**WELWYN HATFIELD BOROUGH COUNCIL  
ASSISTANT DIRECTOR (PLANNING)**

**DELEGATED APPLICATION**

**Application No:** 6/2023/0297/VAR  
**Location:** 50 Plough Hill Cuffley Potters Bar EN6 4DS  
**Proposal:** Variation of condition 2 (drawing numbers) on planning permission 6/2021/1144/VAR  
**Officer:** Ms Kirsty Shirley

**Recommendation:** Refused

EXISTING FRONT
ELEVATION - variation
of condition

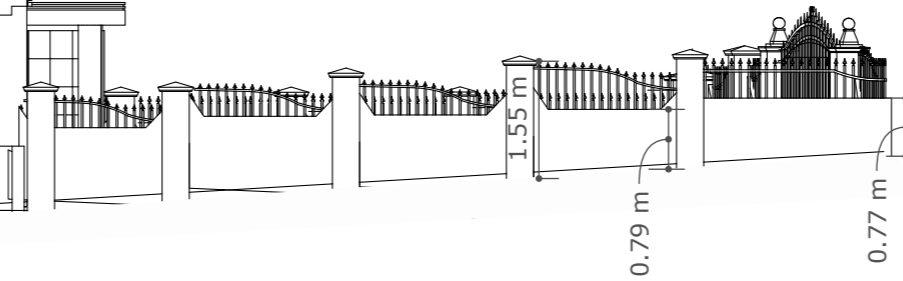
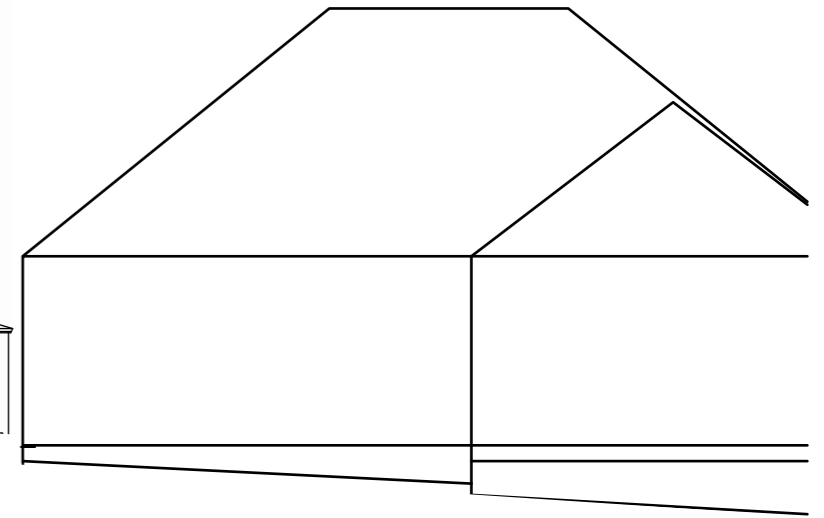
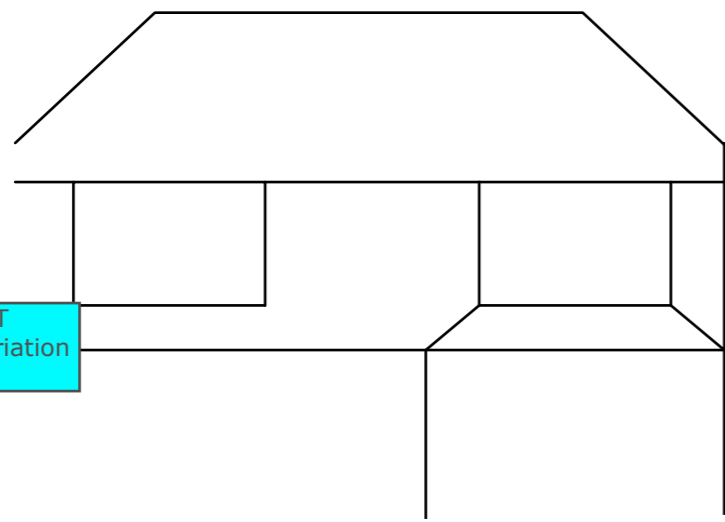
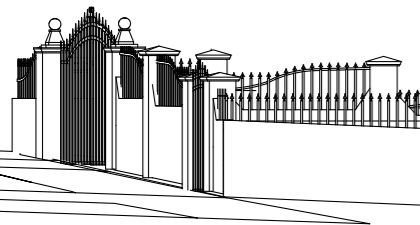
<b>Relevant Policies</b>			
<input checked="" type="checkbox"/> NPPF <input checked="" type="checkbox"/> D1 <input checked="" type="checkbox"/> D2 <input type="checkbox"/> GBSP1 <input checked="" type="checkbox"/> GBSP2 <input type="checkbox"/> M14 <input checked="" type="checkbox"/> Supplementary Design Guidance <input type="checkbox"/> Supplementary Parking Guidance <input type="checkbox"/> Interim Policy for car parking and garage sizes			
<p>The Welwyn Hatfield Draft Local Plan Proposed Submission (August 2016) Incorporating The Proposed Main Modifications (January 2023) (Draft Local Plan) Policies: SADM11, SP9</p>			
<b>Main Issues</b>			
<b>Design (form, size, scale, siting) and Character (appearance within the streetscene)</b>	<p>The proposal is for the retention of alterations to the approved front boundary treatment. Following the commencement of works approved under application 6/2021/1144/VAR, an enforcement case was opened as the proposed boundary treatment erected was not in accordance with the details approved under application 6/2021/1144/VAR.</p> <p>The boundaries of nearby properties tend to be characterised by enclosures that are more recessive in appearance, softened by planting. In this context the front boundary that is the subject of this application, though set back from the highway, because of its height and decoration appears strident and excessively ornate. This is partly because of the white rendered finish to the wall, which is not objectionable because it matched the host dwelling and was previously found acceptable under planning permission 6/2019/2591/HOUSE. Nevertheless, when compared to the approved scheme, the gates and piers have been built taller than previously considered acceptable. Moreover, the detailed design has been altered with significant visual affect, including the</p>

addition of large finials, curved top gates and ornate decoration highlighted in gold paint. Whilst there are some tall boundary structures nearby, none are as high as the proposal, and none are comparable in design. Other examples are constructed from brick, in muted tones, with straight top railing and gates, painted black without elaborate embellishment. The frontage in this case appears obtrusive and incongruous in its immediate surroundings. It introduces a harder edge, that draws the eye and is at odds with the softer character of nearby boundaries. The implemented front boundary treatment therefore results in harm to that character and appearance of the area.
<b>Impact on neighbours</b>	No neighbour representations have been received.  The proposed alterations would not result in adjoining neighbours to experience an undue loss of light, nor would the development appear overbearing or unduly dominant.

1. The design, height and scale of the implemented boundary treatment detrimentally detracts from the character and appearance of the area, contrary to Policies D1 and D2 of the Welwyn Hatfield District Plan; Policies SADM11 and SP9 of the Welwyn Hatfield Draft Local Plan Proposed Submission (August 2016) Incorporating the Proposed Main Modifications (January 2023); the Supplementary Design Guidance; and the National Planning Policy Framework.
